# Rezoning Transportation Analysis

Petition Number: 2021-114

Date	Description
09-15-21	First Review (BKB)
10-18-21	Second Review (AO)

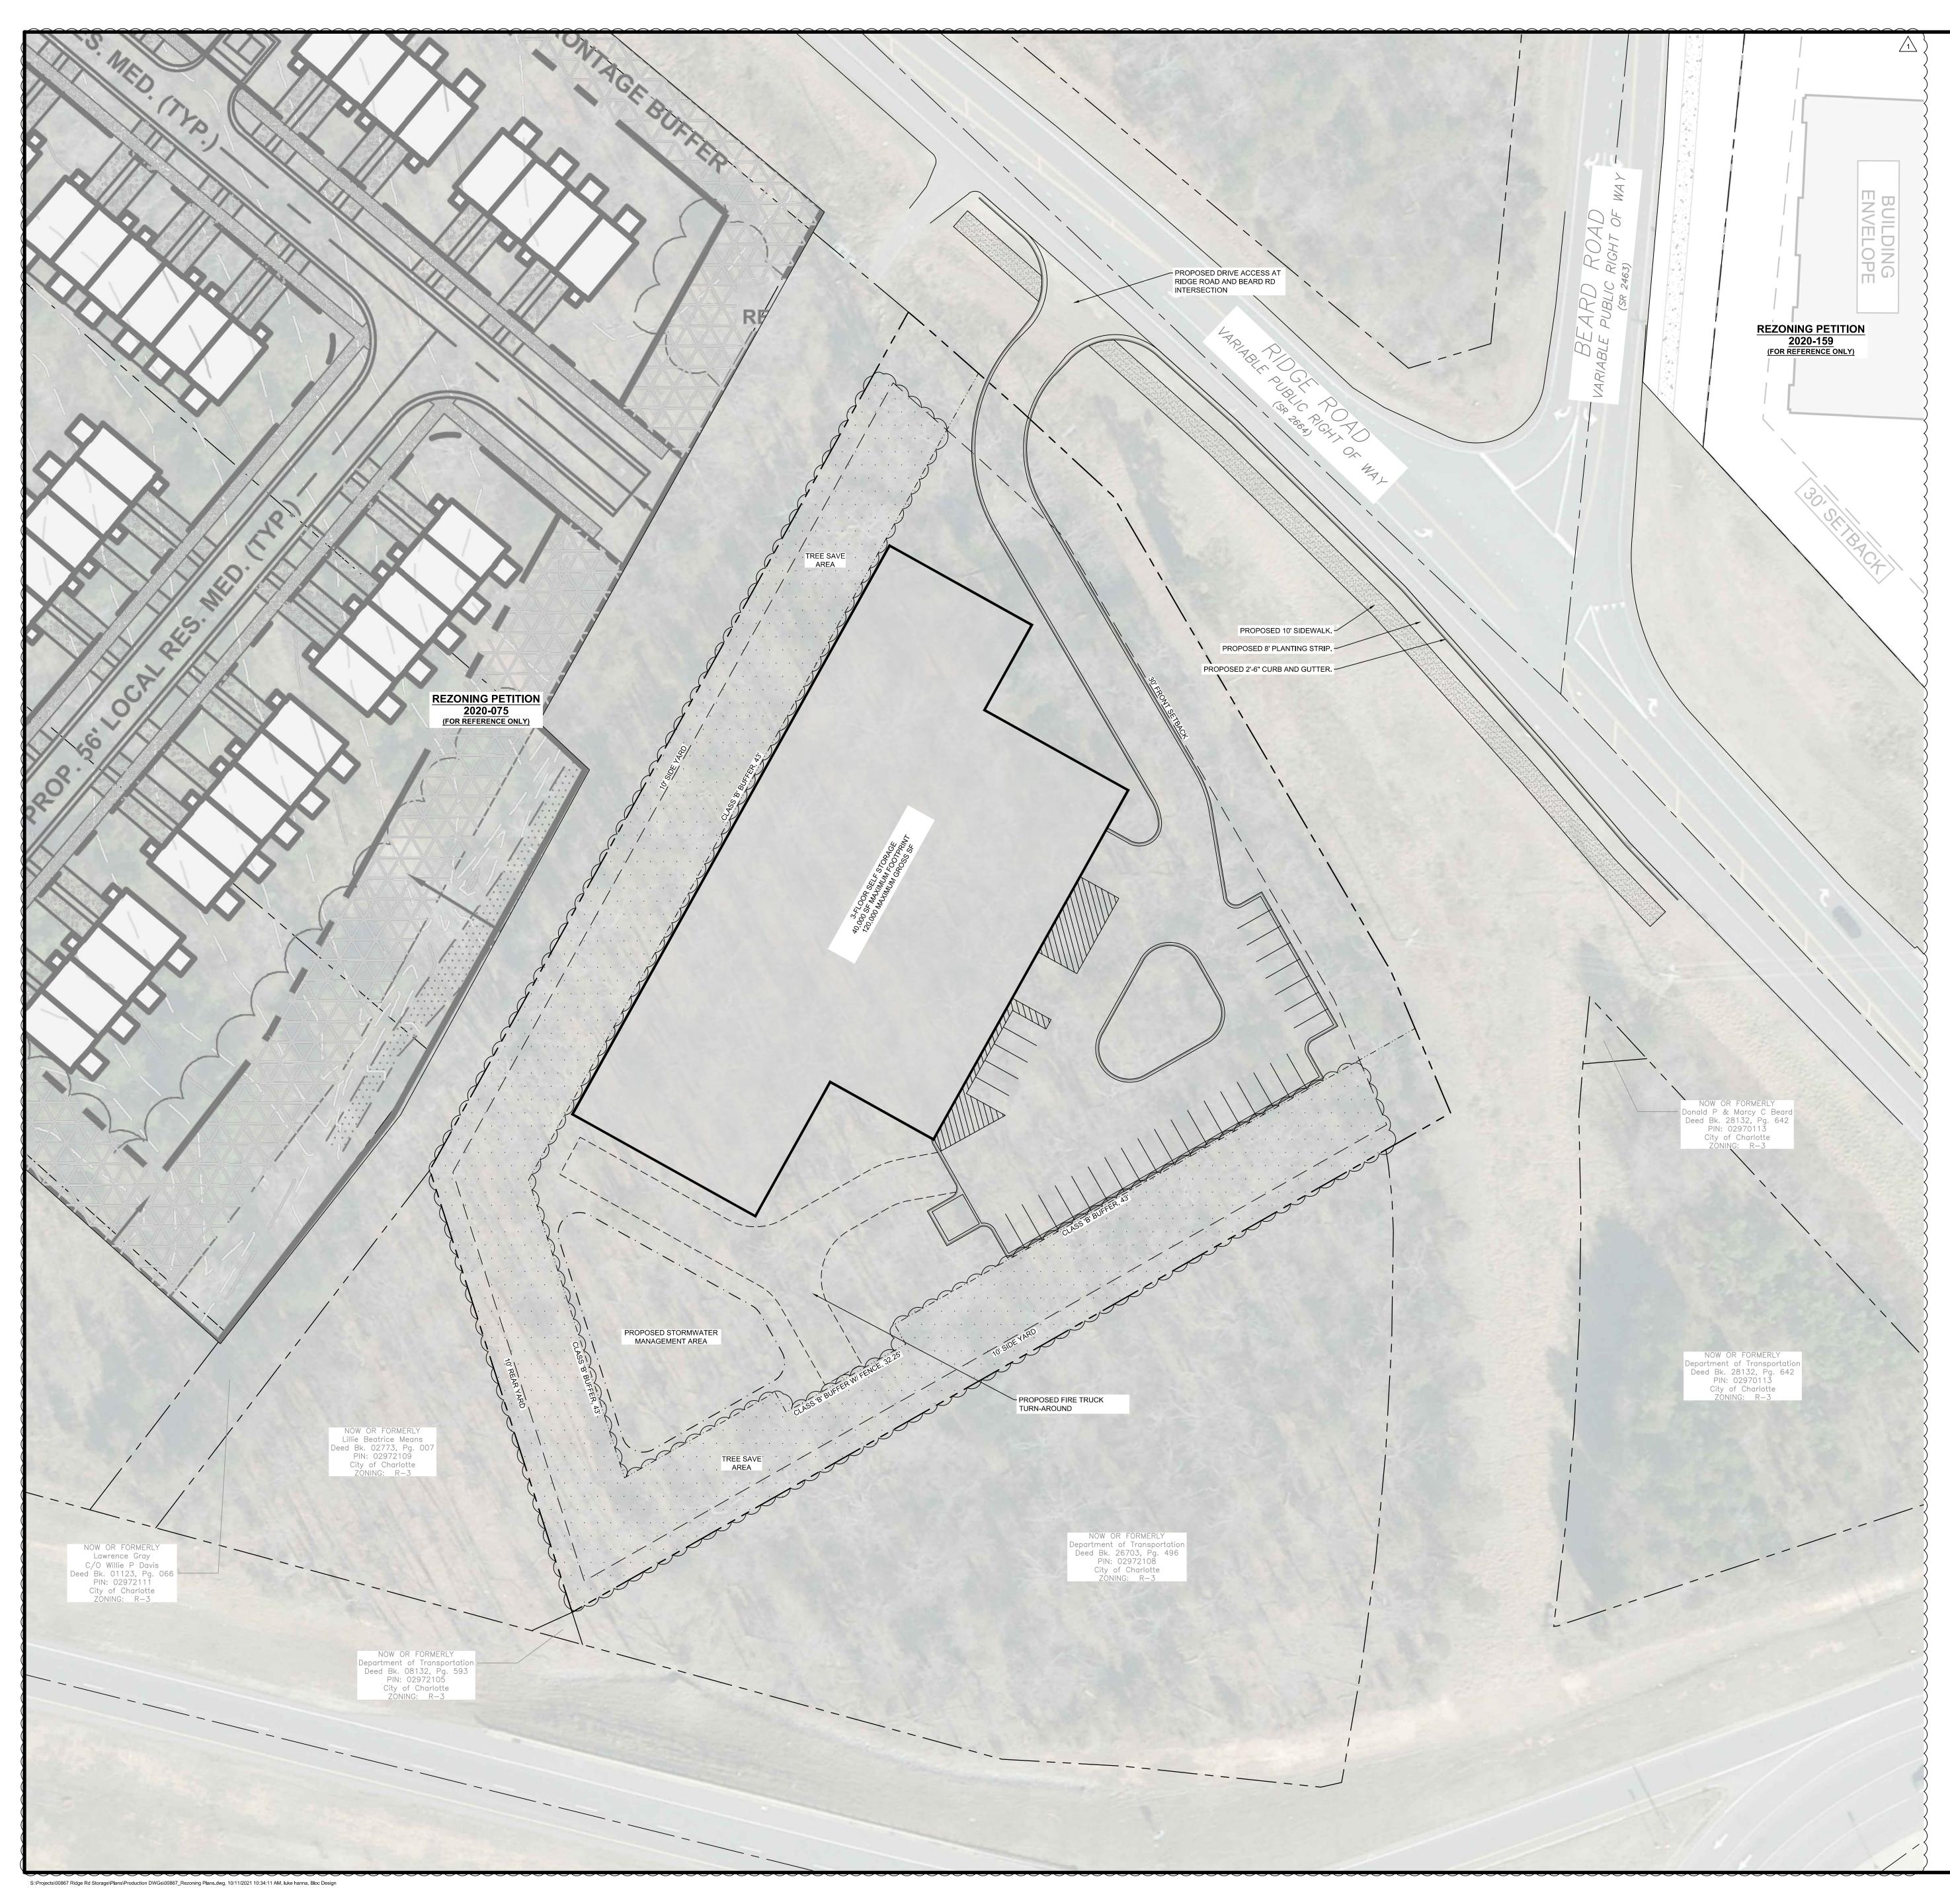
1. **Curblines:** The proposed zoning district has a setback measured from back of the existing or proposed future curblines.
  - a. **Ridge Road:** Provide curb and gutter along existing edge of travel lane along the entire property frontage. Use existing edge line for placement of gutter.

Label and dimension the curb and gutter from the centerline for Ridge Road on the site plan.

**Clarifying Comment from 9-15-21: Place curb and gutter off of edge of travel lane, not existing edge of pavement. Dimension the curb and gutter from the centerline of Ridge Road.**

4. Site plan and revisions are needed to reflect the access point to the development on the western portion of the property per the below image. The existing Ridge Road and Beard Road intersection would require improvements that aren't commensurate with the development, so this relocated driveway will require less improvements of the developer within Ridge Road.
